# A428 Black Cat to Caxton Gibbet improvements

9.46 Applicant's Comments on Deadline 3 Submissions

**9.46 Applicant's Comments on Deadline 3 Submissions**

**Figure 6-1 –Junction Models - Cambridgeshire**

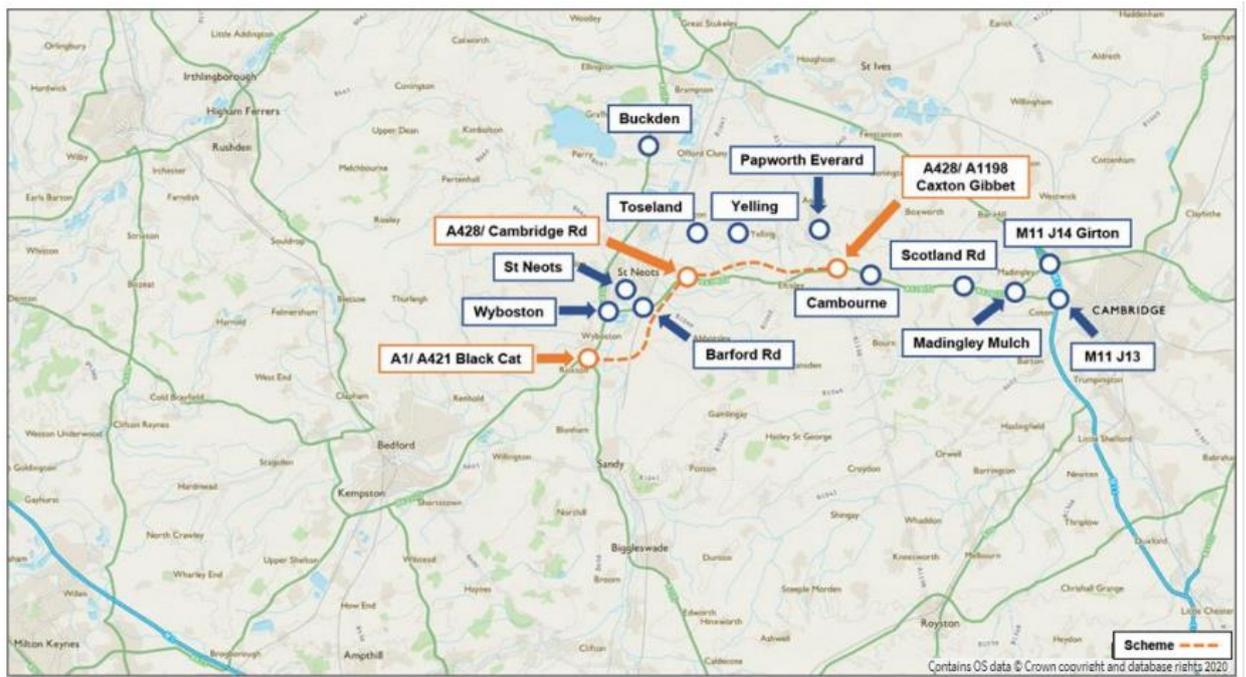
Reference Number	Interested Parties Submission/Applicant's Comments
	<p>Mr Allatt explained that, at a high level, CCC are not satisfied that the junction models are robust because CCC do not have validated base models for local junctions and therefore cannot draw solid conclusions about what the impacts on the local network will be.</p> <p>The ExA asked what high-level risks this poses to the LHA.</p> <p>Mr Allatt explained that CCC would not understand the impacts of the A428 on the LHA's network and therefore the risk of that network being appropriately designed and mitigated. Modelling feeds into the assessment of a whole cross section of areas concerning impacts including highway design, mitigation, traffic management and noise.</p> <p>Mr Allatt further explained that CCC have provided the Applicant with a whole range of existing data that would allow those base models to be validated. CCC is of the view that adding this extra level of robustness would be readily achievable so that CCC can be confident in the outputs. CCC has undertaken some spot-checks of the model and have found some disparities and are in discussions with the Applicant on this matter.</p> <p>Mr Tyrrell referred to section 2.3 of the Cambridgeshire Councils' Written Representations [REP1-048] which provides some examples of the specific risks and concerns which flow from the lack of validation at various locations.</p> <p>Scott Lyness QC on behalf of the Applicant explained that this issue needs to be considered in light of three categories of junction as explained in the Junction Modelling Technical Note [REP1-030]:</p> <ol style="list-style-type: none"> <li>a. Junctions which do not exist in the base year, or where there are fundamental changes in layout, referred to as 'Scheme junctions'.</li> <li>b. Junctions which do exist in the base year and are not significantly changed by the Scheme, but where no base models were developed, referred to as 'existing junctions with no calibrated/validated base models'.</li> <li>c. Junctions which do exist in the base year and are not significantly changed by the Scheme, but where observed data was available and base models were developed, referred to as 'existing junctions with calibrated/ validated base models'.</li> </ol> <p>Mr Lyness explained that the third category is not relevant to the current discussions. In relation to the first category, the changes are so fundamental that existing flows are not going to be of much assistance. In relation to the second category, the basic position is that the scheme would result in either a significant capacity improvement at a junction with an existing capacity issue or, where the scheme increases traffic flows, the junction is predicted to operate under capacity by a large margin.</p>

Reference Number	Interested Parties Submission/Applicant's Comments
	<p>In response to this explanation on the second category of junctions, Mr Tyrrell explained that CCC has concerns as to whether one can be confident that there is a significant capacity improvement or an increase in flows which does not present an issue for the local highway network without the required validation.</p> <p>In relation to the first category of junctions, Mr Tyrrell explained that CCC has concerns relating to the notion that some of the changes to the scheme are so fundamental that validation is not worth pursuing. Mr Tyrrell invited Lou Mason-Walsh to explain further.</p> <p>Ms Mason-Walsh reiterated CCC's concerns about the way in which the modelling has been carried out because the impact on the local road network cannot be assessed. It is not sufficient to state that somewhere sees a benefit or, for example, that 4 arms of a 5 arm junction see a benefit when one arm sees a disbenefit and the impacts on the adjacent junctions have not been assessed.</p> <p>Mr Allatt commented, in response to Samaya Ghosh's submission on behalf of the Applicant that validation had been carried out where it was considered to be necessary, that it was important to factor in where the LHA considered validation to be necessary as the authority responsible for the local highway network, particularly where the data exists to validate the model.</p> <p>The ExA asked CCC whether CCC holds existing count data for some of the relevant locations and Mr Allatt confirmed that CCC does hold that data.</p> <p>The ExA asked whether CCC could assist with the provision of that count data. Mr Allatt confirmed that CCC had been in discussion with the Applicant on this matter and that links to the data had been provided. CCC have set out how CCC's concerns could be addressed.</p> <p>In response to the submission by the Applicant that validation would not assist the analysis of the category 1 'scheme junctions' as the changes were fundamental, Mr Tyrrell emphasised that CCC disagrees with this view because none of the new junctions in Cambridge are providing for any movements that are not currently possible but instead separate out the local and strategic traffic, which does not justify disregarding the local information. The Applicant is not creating something new which is non-existent and there is therefore utility and value in carrying out the validation by reference to the existing information on all of the junctions.</p> <p>Mr Tyrrell highlighted that the approach being taken is that a model conceived for strategic roads and was not conceived for local roads is being applied to local roads and, because the effects are noted as beneficial, the results are not being double-checked. It would seem that the Applicant is building assumption on assumption without an understanding of whether it reflects the reality on the ground.</p>

Reference Number	Interested Parties Submission/Applicant's Comments
Applicant's comment	As a follow-on action from ISH2 the Applicant is currently undertaking a series of sensitivity tests on a set of selected junctions in line with the Joint Position Statement with the Local Highway Authorities on Junction Modelling [REP3-024] and the Scope of Junction Model Sensitivity Test [REP3-029], both submitted at Deadline 3. The sensitivity tests are being undertaken by amending the model input parameters in line with CCC's suggestions and the outputs from these tests will be considered in due course.
Section 4 – Anticipated operational traffic effects on the surrounding highway network b. Potential impacts at roads and junctions identified in CCC, HDC and SCDC Joint Local Impact Report [REP2-003] (ii) Coton	
REP3-035b	<p>The ExA noted that the Applicant had provided a Technical Note in relation to Traffic Routeing Impacts at Coton [REP1-028] and invited CCC to confirm whether this dealt with its concerns and if not, why not.</p> <p>Ms Mason-Walsh explained that the Technical Note confirms that the model is wrong. This is consistent with CCC's conclusion and so CCC agrees with the Applicant that the predicted flows are not necessarily as shown by the model.</p>
